ENRMF Western Extension (WS010005) – Deadline 7 submissions

Schedule 1 to the letter to PINS dated 20 July 2022**A summary of the current position regarding the water pipe standoffs agreed between the Applicant and Anglian Water as at 20 July 2022**

Figure ESA5.1 Scale: 1:2,500@A2

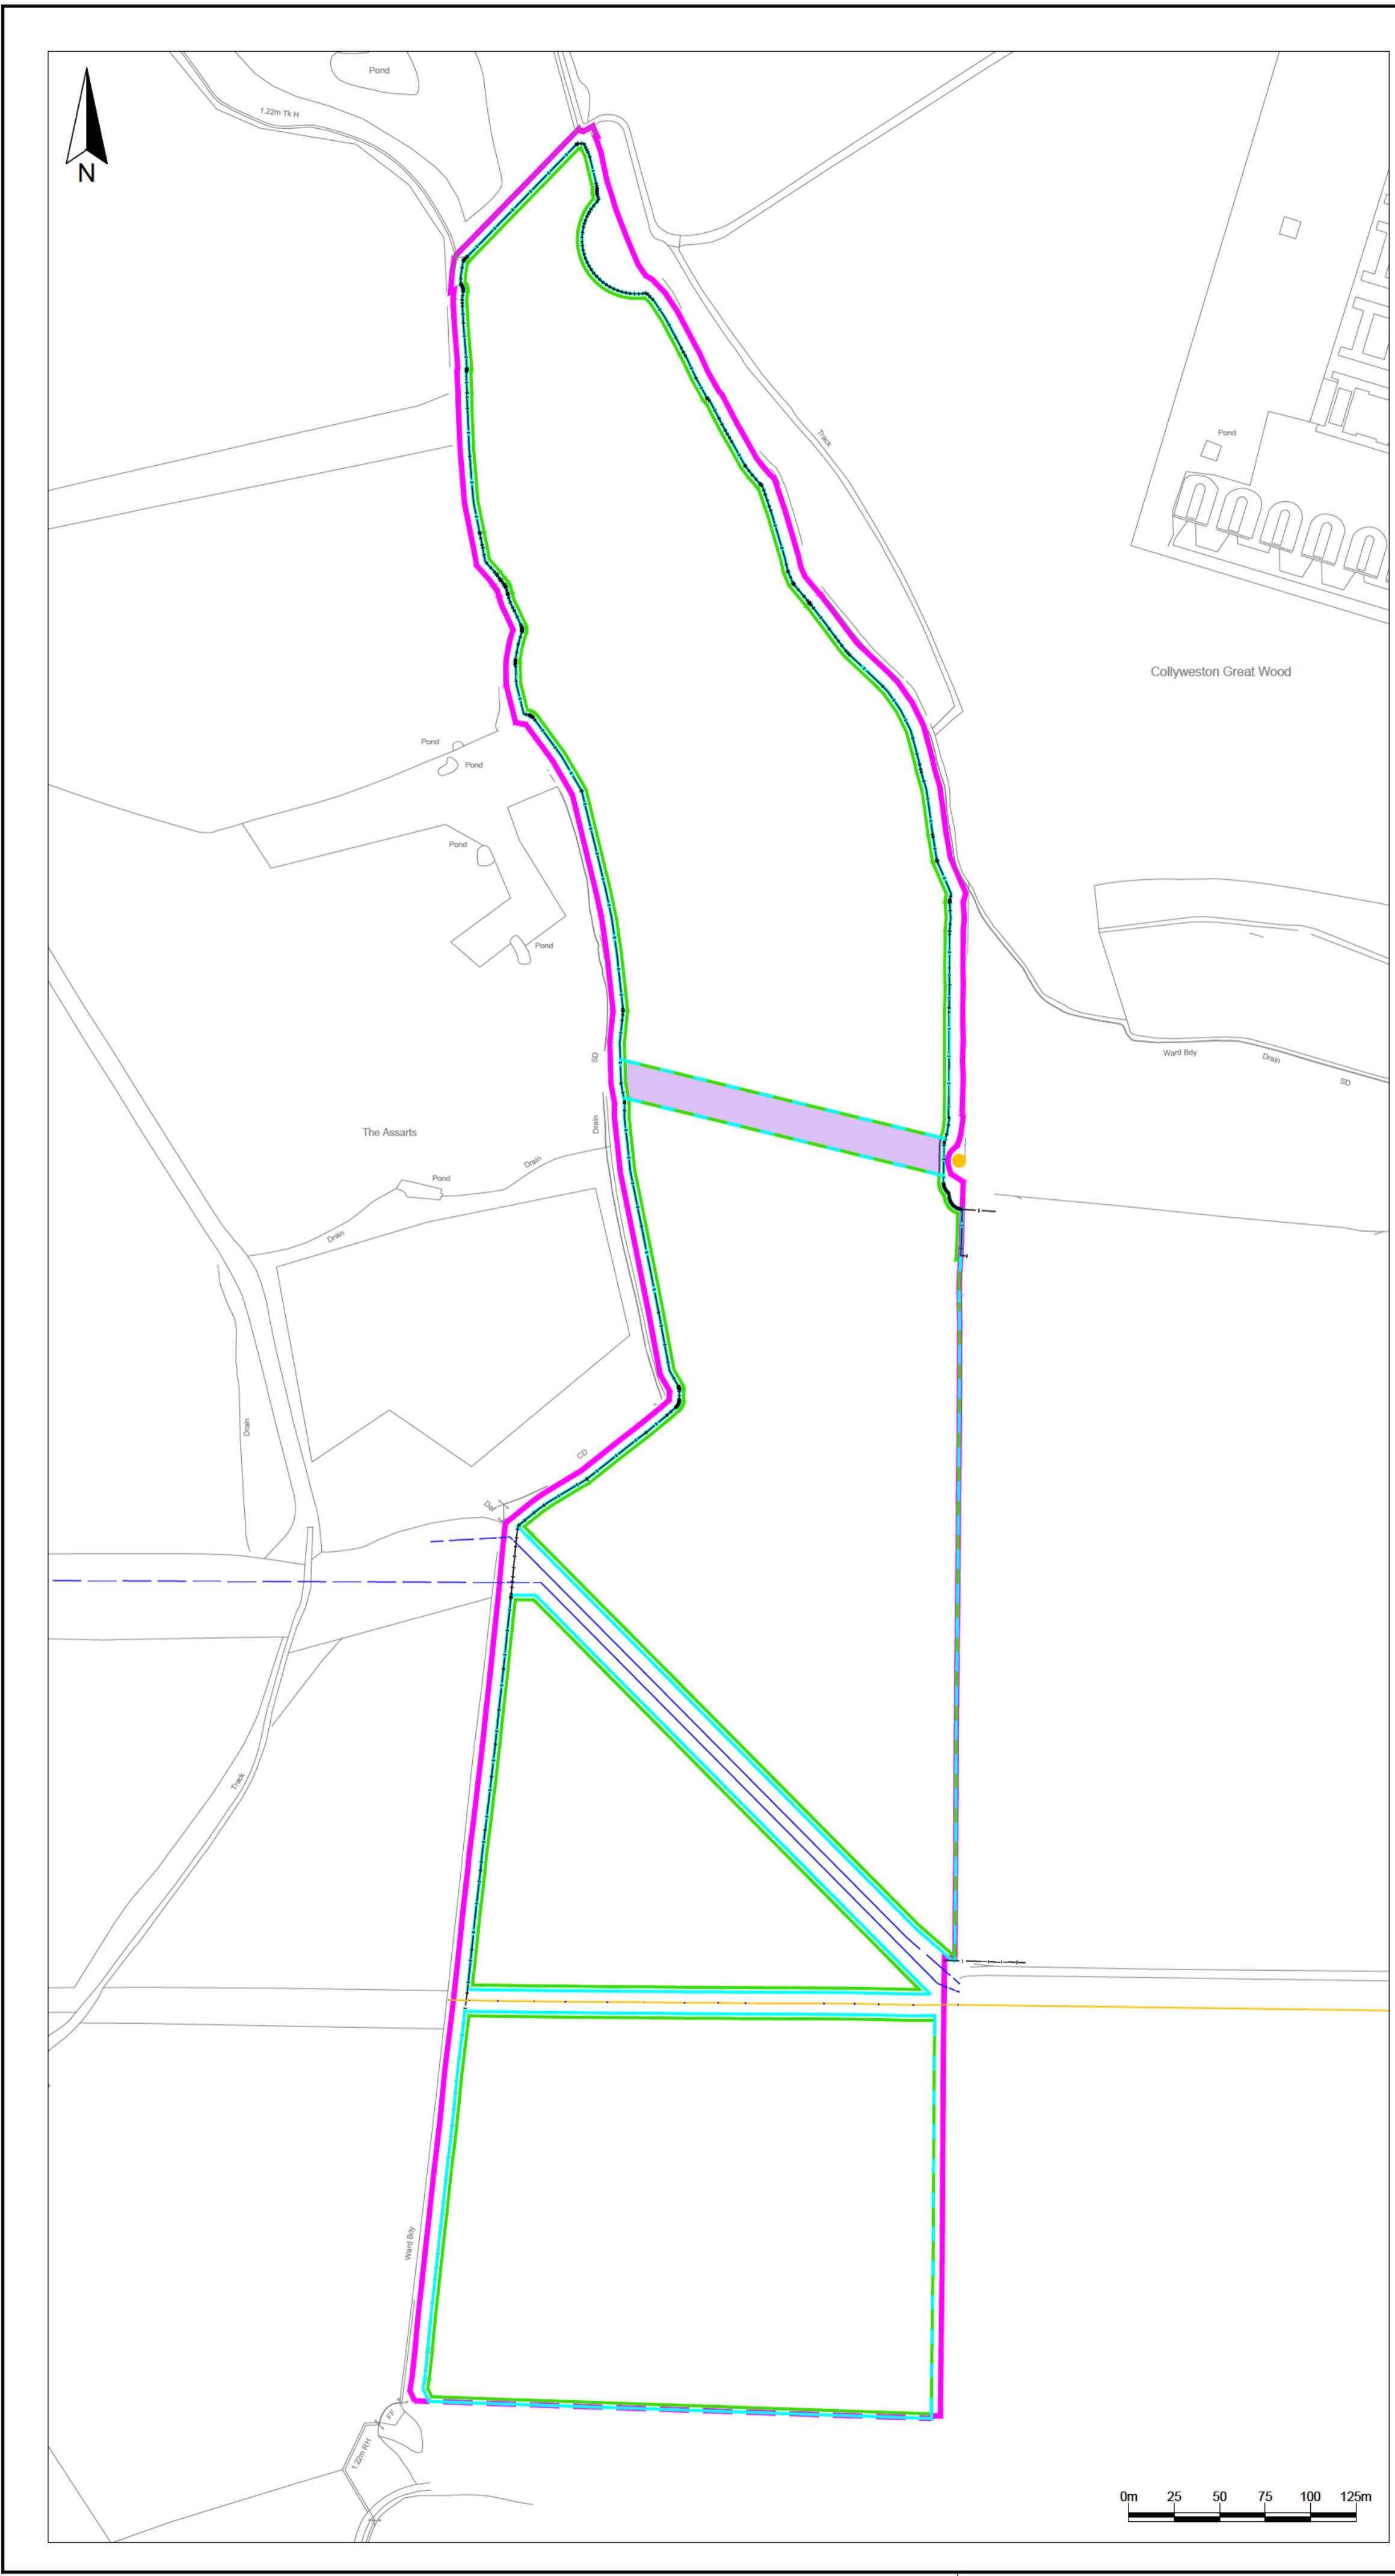
Subject to the agreement of bespoke Protective Provisions (which are incorporated into the dDCO) Anglian Water have agreed to a standoff from the water pipes of 20m. Changes have been made to Table DEC B1 of Appendix B of the DCO Environmental Commitments document (PINS document reference 6.5. (V3) submitted at Deadline 7) as follows, the distances are to the fence line as specified in Appendix DEC B:

~~Between a 7m and 30m~~ A 20m standoff from the water pipeline.

~~A minimum 3.5m stand off from the diverted electricity cable (which will be located within the 7m to 30m standoff for the water pipeline).~~

~~Between a 7m and 30m~~ A 20m standoff from the water pipeline.
